## **APPEAL STATEMENT OF CASE**

| <b>Planning Inspectorate Reference:</b> | APP/T2350/W/23/3325434 |
| <b>LPA Application Reference:</b>       | 3/2023/0226            |

**Prior notification application for the proposed conversion/redevelopment of two agricultural buildings into two dwellings**

SHEET: BARN 1 EXISTING AND
PROPOSED PLANS AND
ELEVATIONS

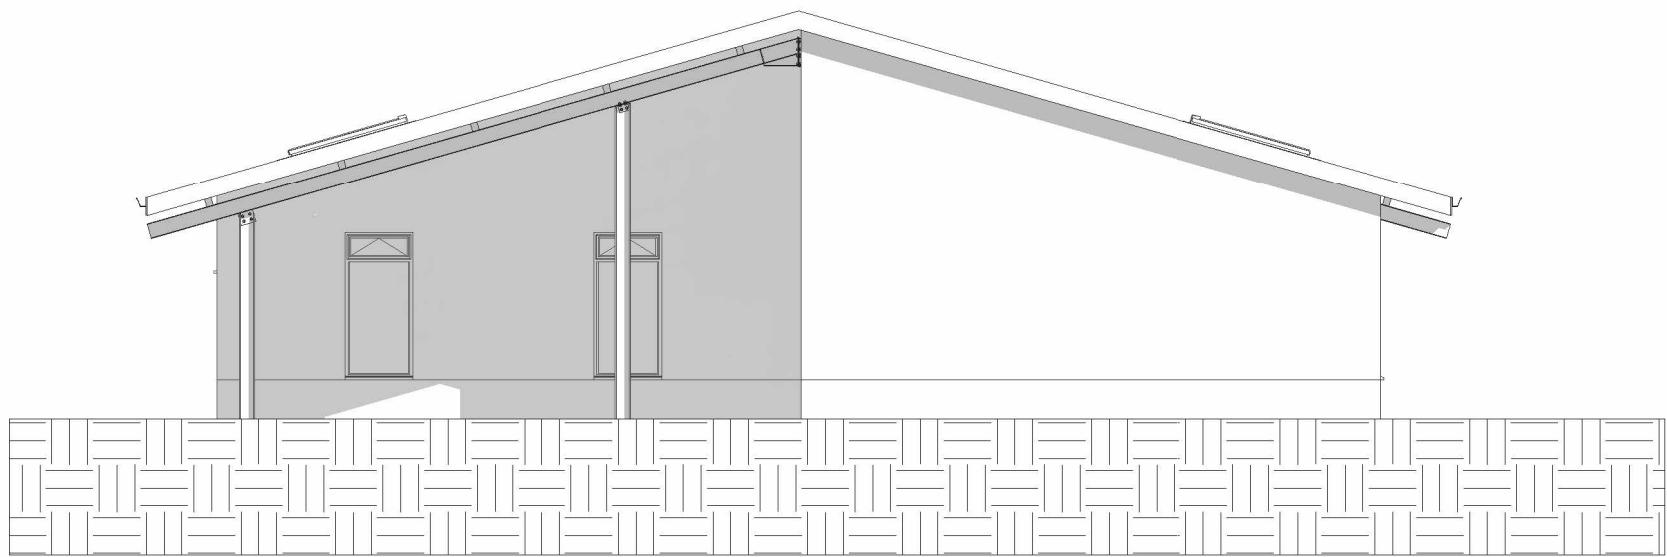
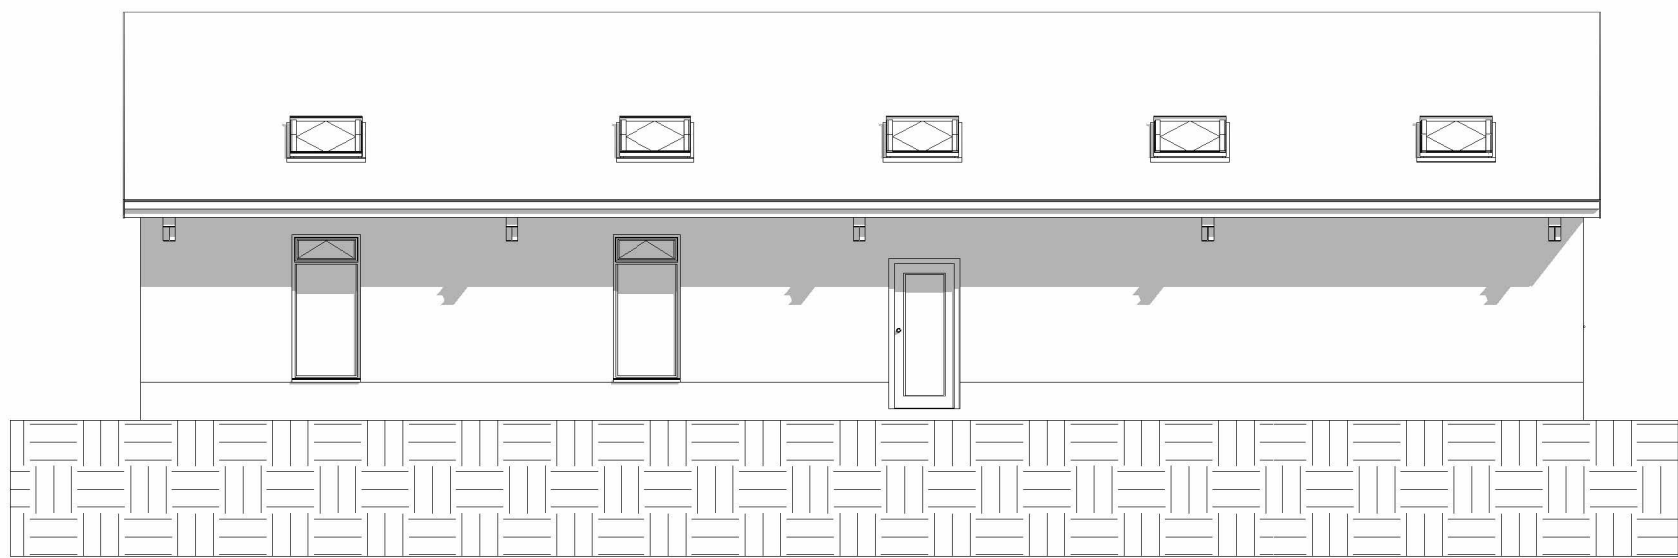
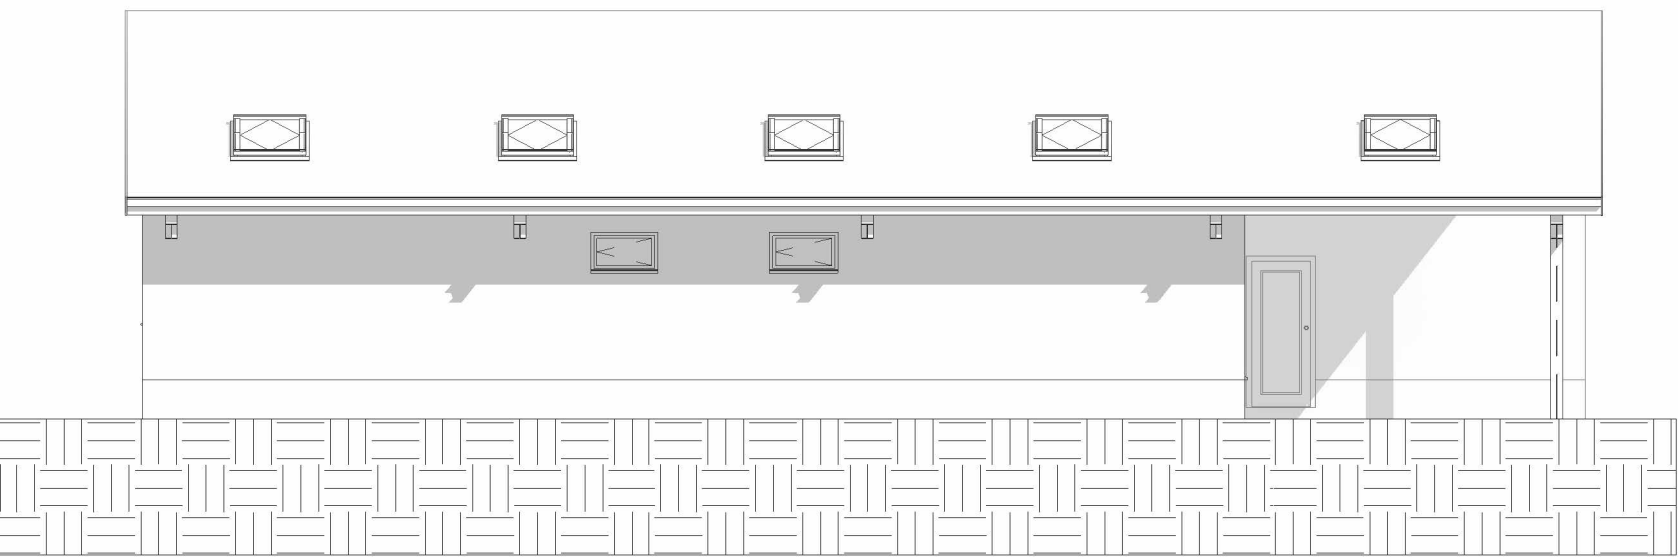
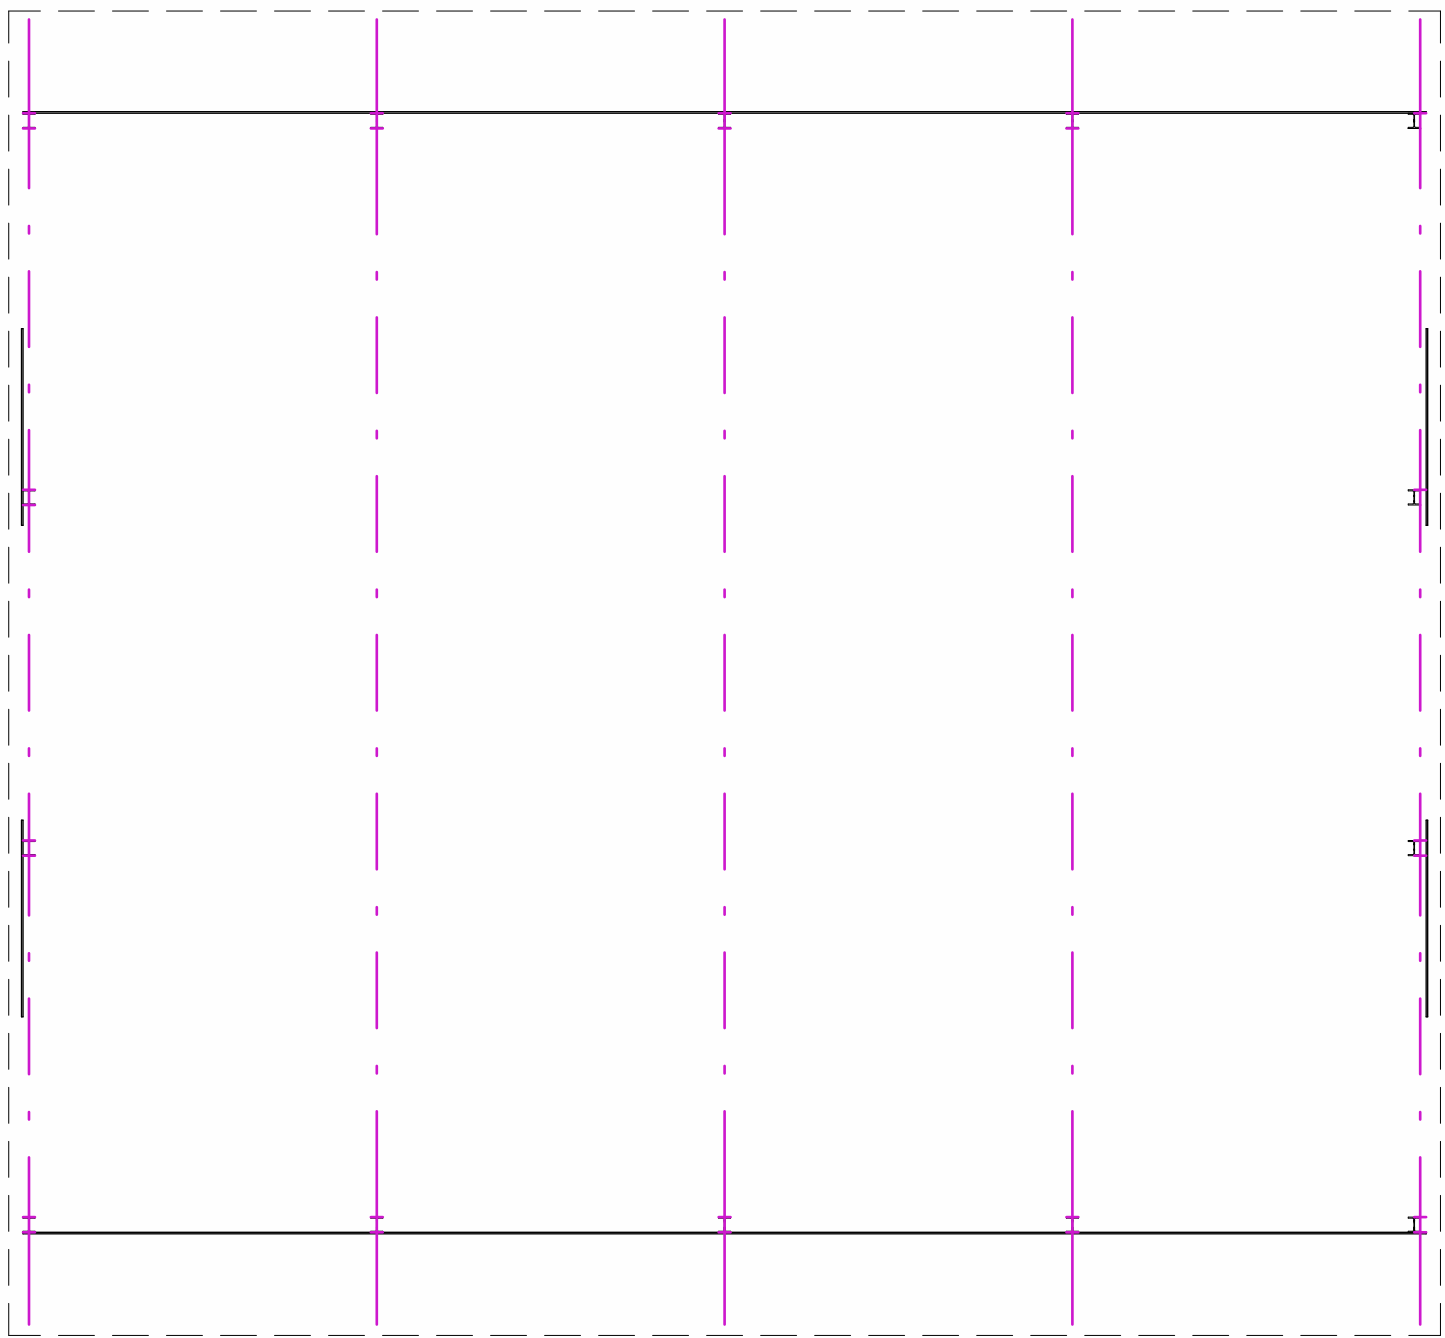
- 7.3 Taking into account the proposed changes in design and materials Barn 1 would have ten regular sized and placed rooflights including one over the overhang to the south east. This together with regular doors and windows proposed to the south west, south east and north east elevations results in an overtly domestic appearance with the introduction of three large, glazed elements on the north west elevation has the appearance of 'retro-fitting' a residential use into buildings not designed for such a use.

SHEET: BARN 2 EXISTING AND
PROPOSED PLANS AND
ELEVATIONS

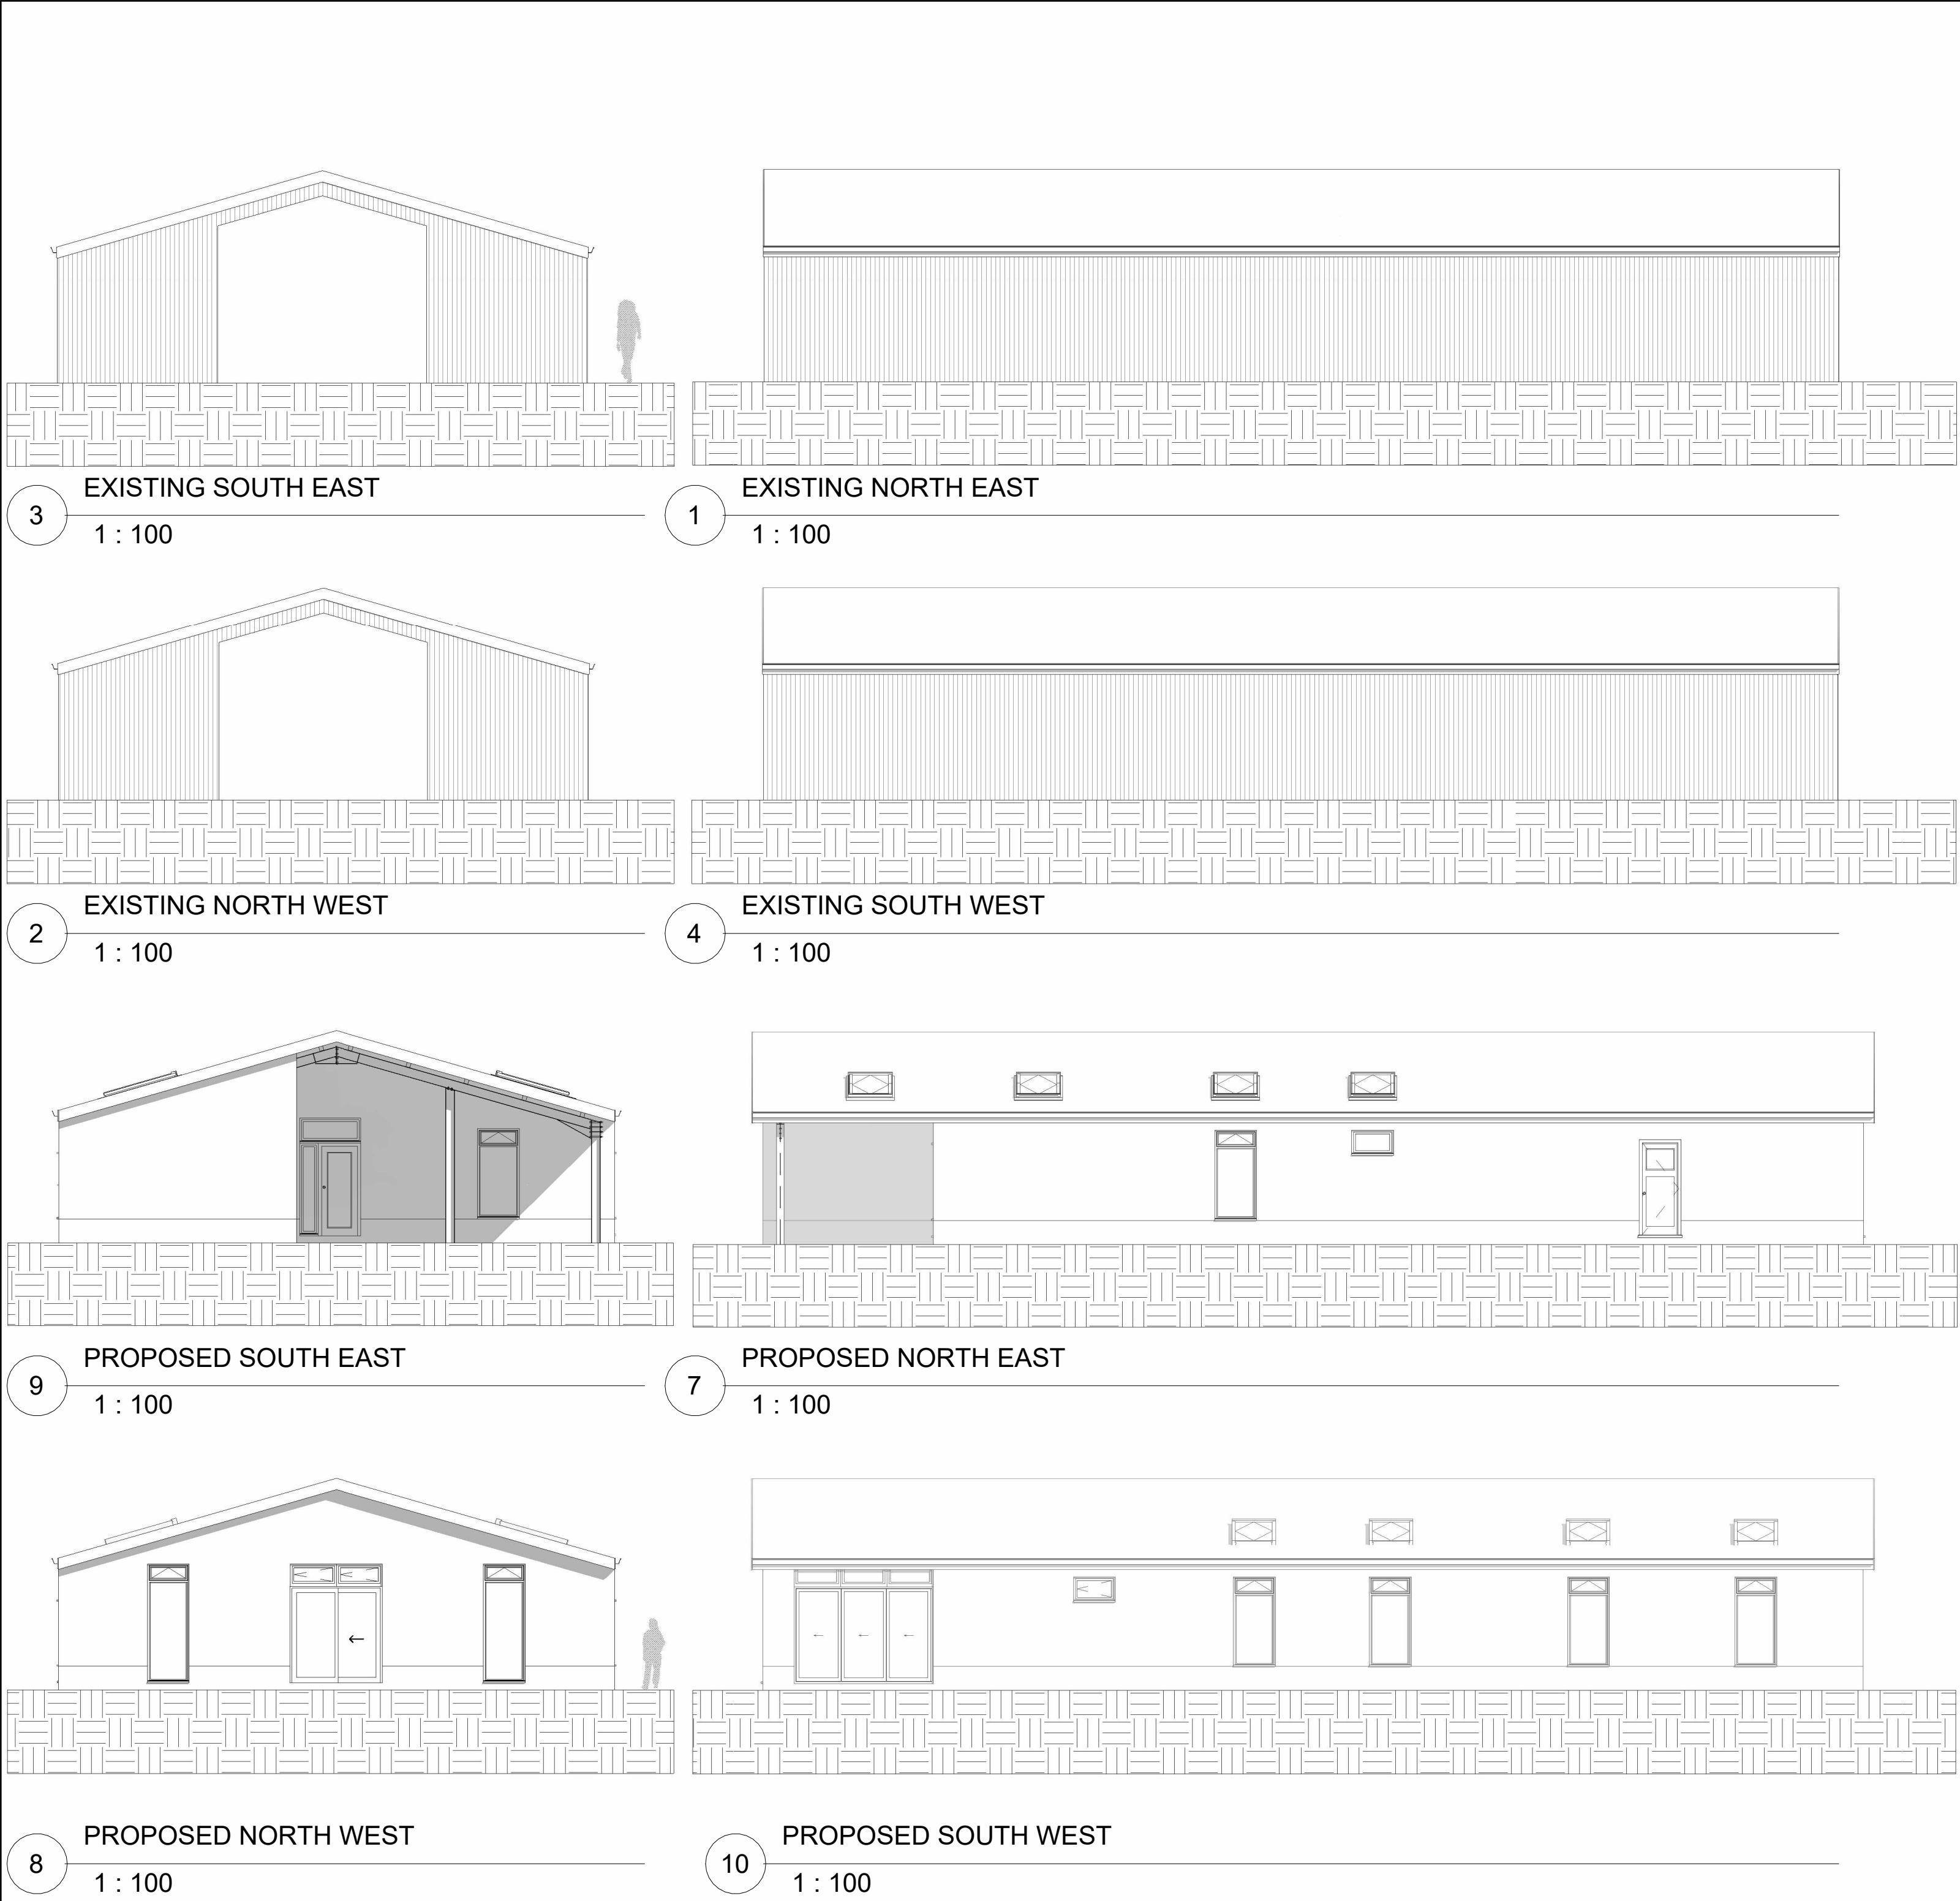
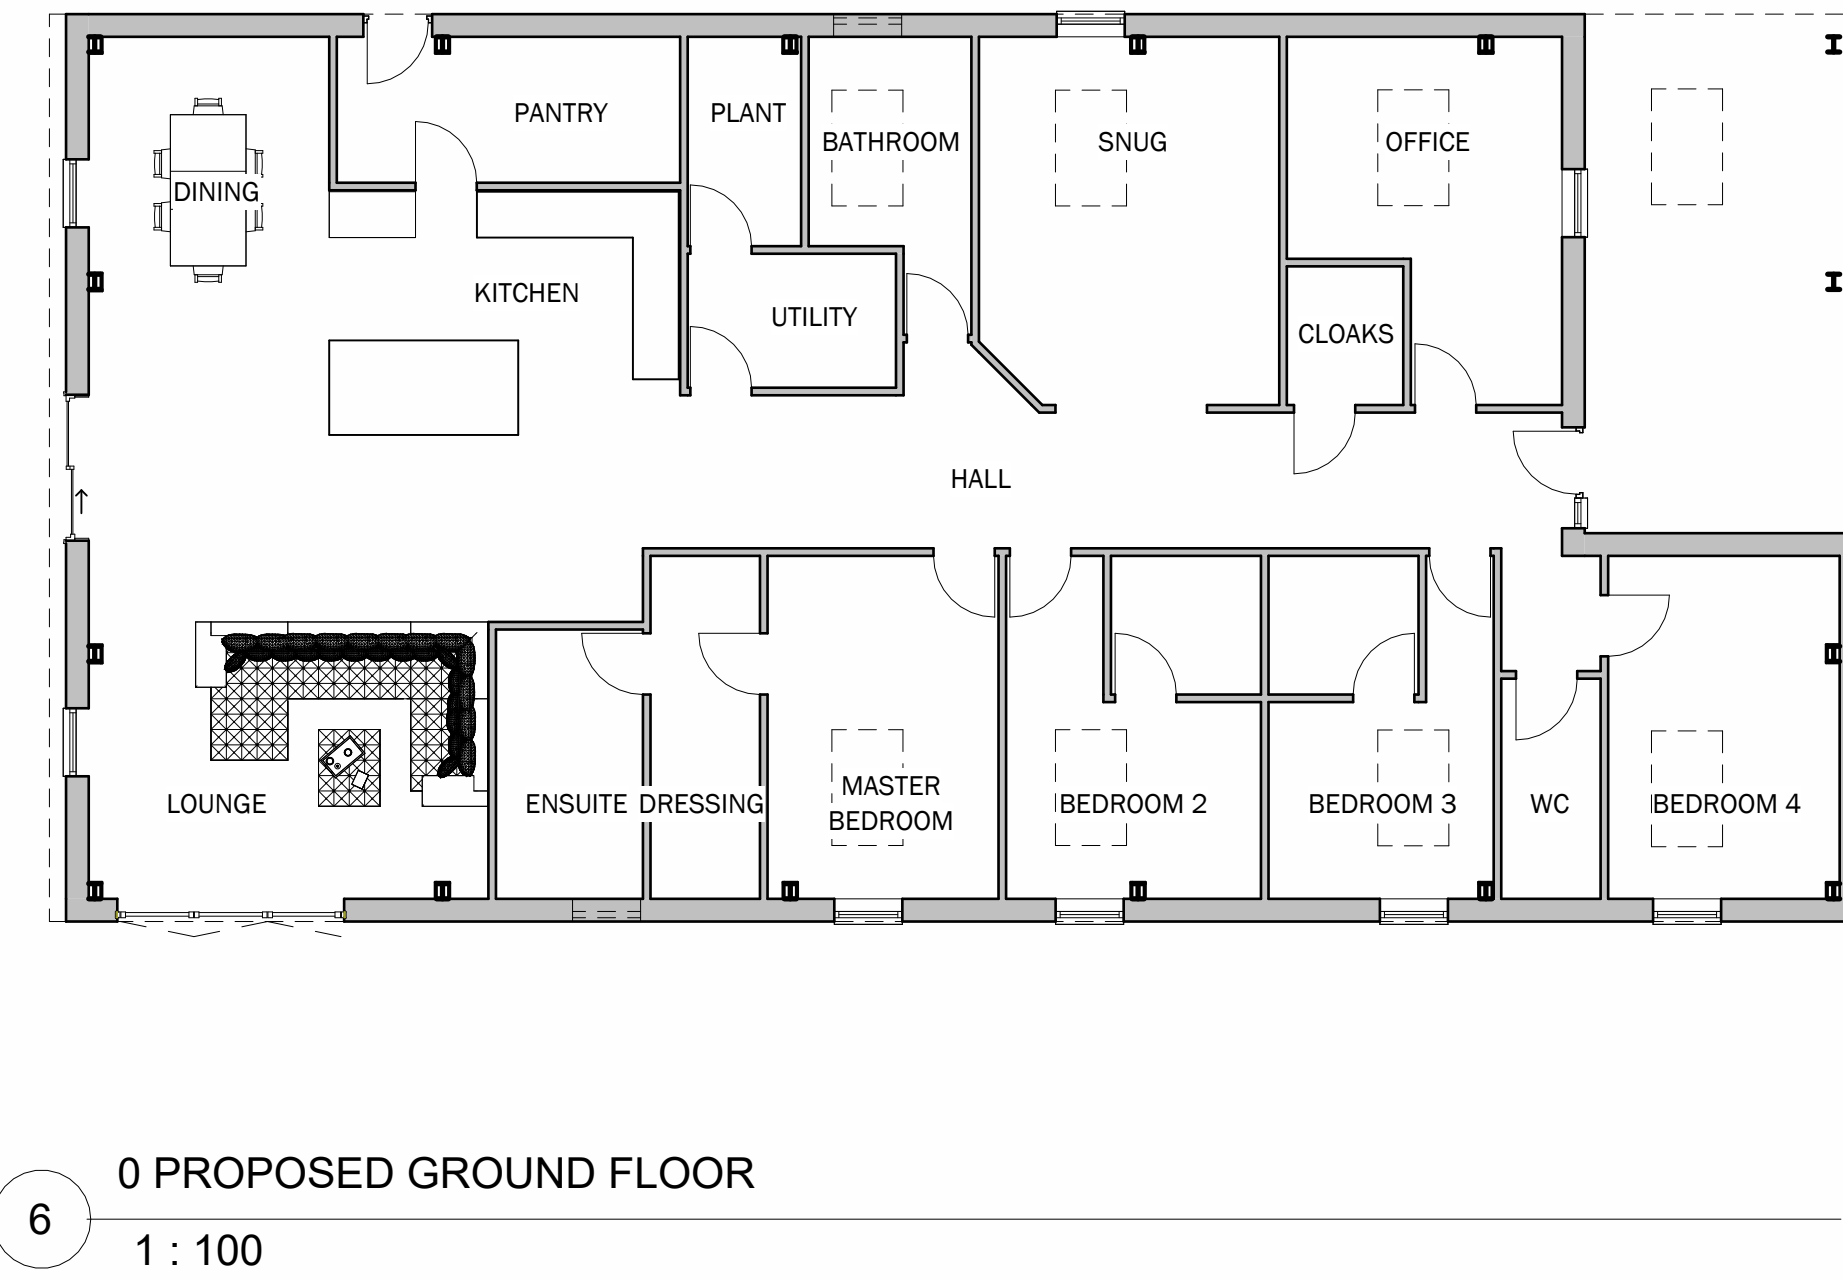
- 7.4 Barn 2 would have eight regular sized and placed rooflights including one over the overhang to the south east this together with regular doors and windows proposed to the all four elevations results in an overtly domestic appearance with the introduction of two large, glazed elements on the north west and south west elevations has the appearance of 'retro-fitting' a residential use into buildings not designed for such a use.
